<b>Consultation Response from KC, Lead Local Flood Authority</b>		
<b>2020/92546 Land off, Blackmoorfoot Road and Felks Street, Crosland Moor, Huddersfield, HD4 7AD</b>		
<b>Outline application (with details of points of access only) for the development of up to 770 residential dwellings (Use Class C3), including up to 70 care apartments (Use Classes C2/C3) with doctors surgery of up to 350 sq m (Use Class D1); up to 500 sq m of Use Class A1/A2/A3/A4/A5/D1 floorspace (dual use), vehicular and pedestrian access points off Blackmoorfoot Road and Felks Stile Road and associated works.</b>		
<b>Date Responded: 3<sup>rd</sup> November 2020</b>	<b>Responding Officer: Paul Farndale</b>	<b>Responding Ref:</b>

**Kirklees Flood Management & Drainage acting as Lead Local Flood Authority, statutory consultee for surface water management, OBJECTS to this application on the grounds that flood risk and drainage strategy goes against advice previously given under application 2018/90748 and pre-application advice.**

Appendix 6: Preliminary Drainage Strategy

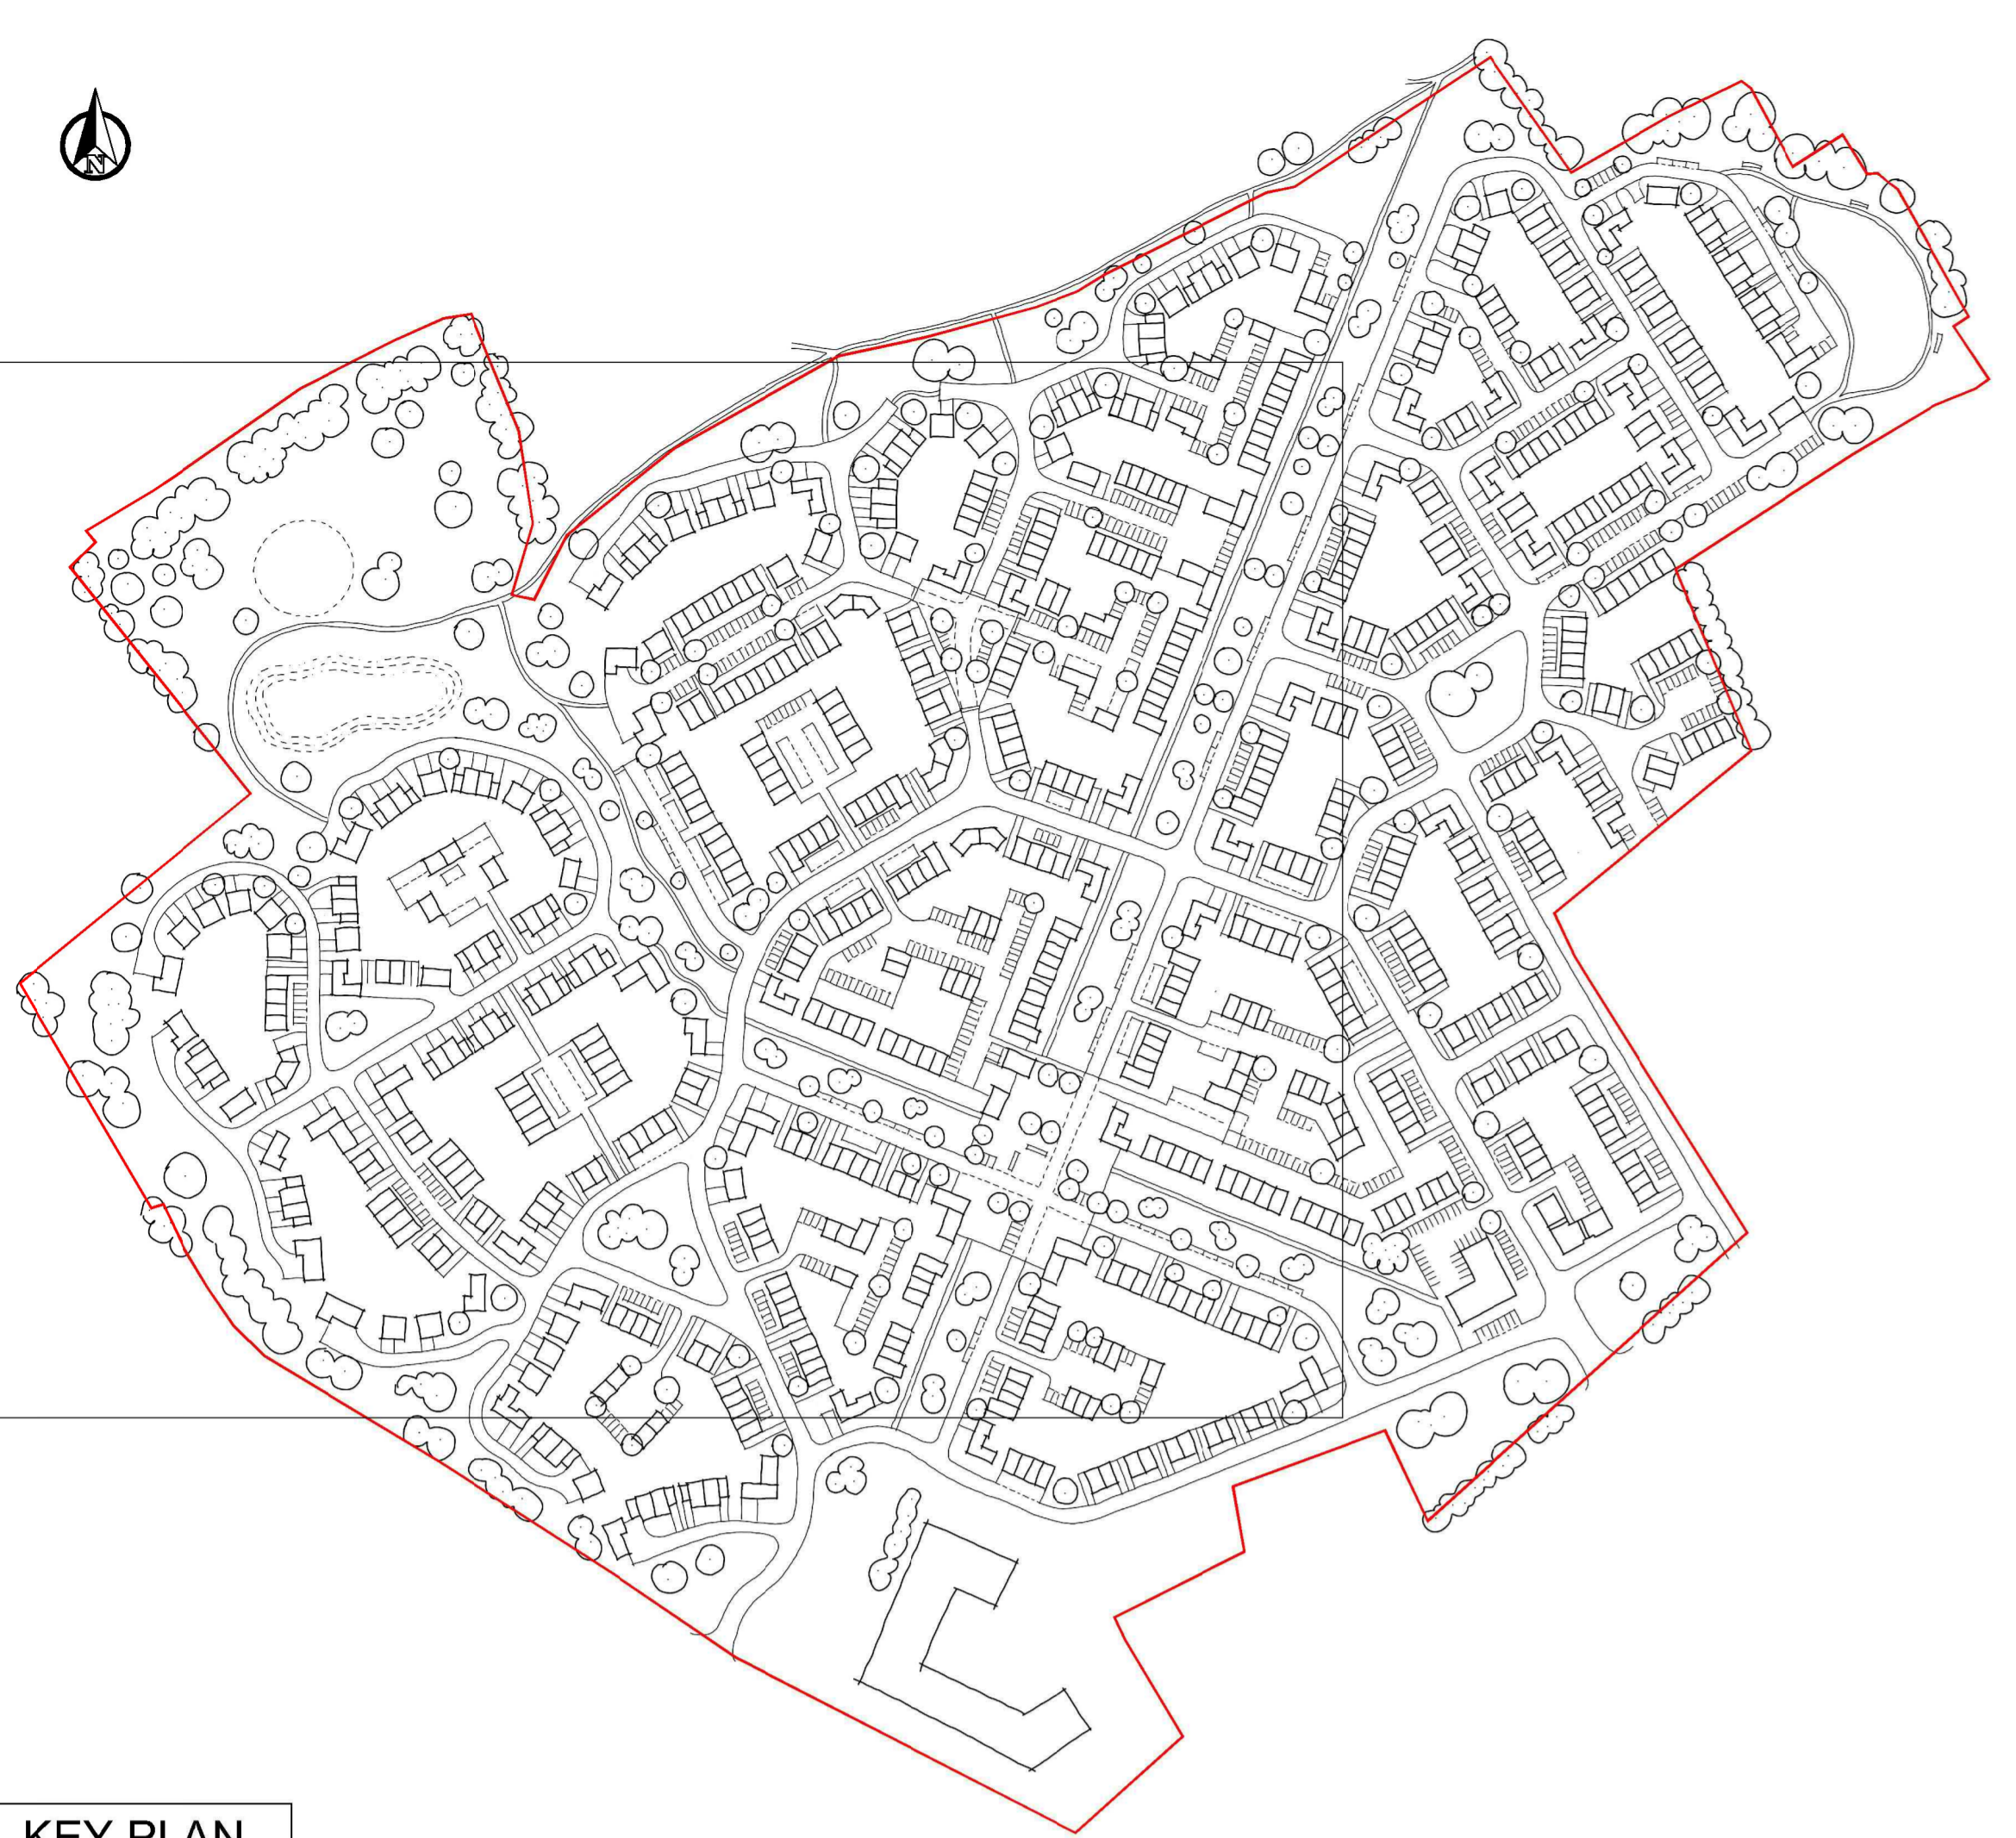
An indicative drainage plan showing infiltration swales, detention ponds and crate storage should therefore be ignored. Despite being indicative Kirklees LLFA are concerned that no indication of overland flow routes for the existing site has been assessed in the FRA and therefore shown how this would change potentially through development. In terms of flood risk management, a developer should always look at potential mains drainage and attenuation location and examine blockage scenarios and exceedance events. These should be confined to road networks and open space avoiding property and curtilage. As a result, the FRA is incomplete and should include all the above and other pre-application advice as an official consultation with the LLFA which is also missing from the document.
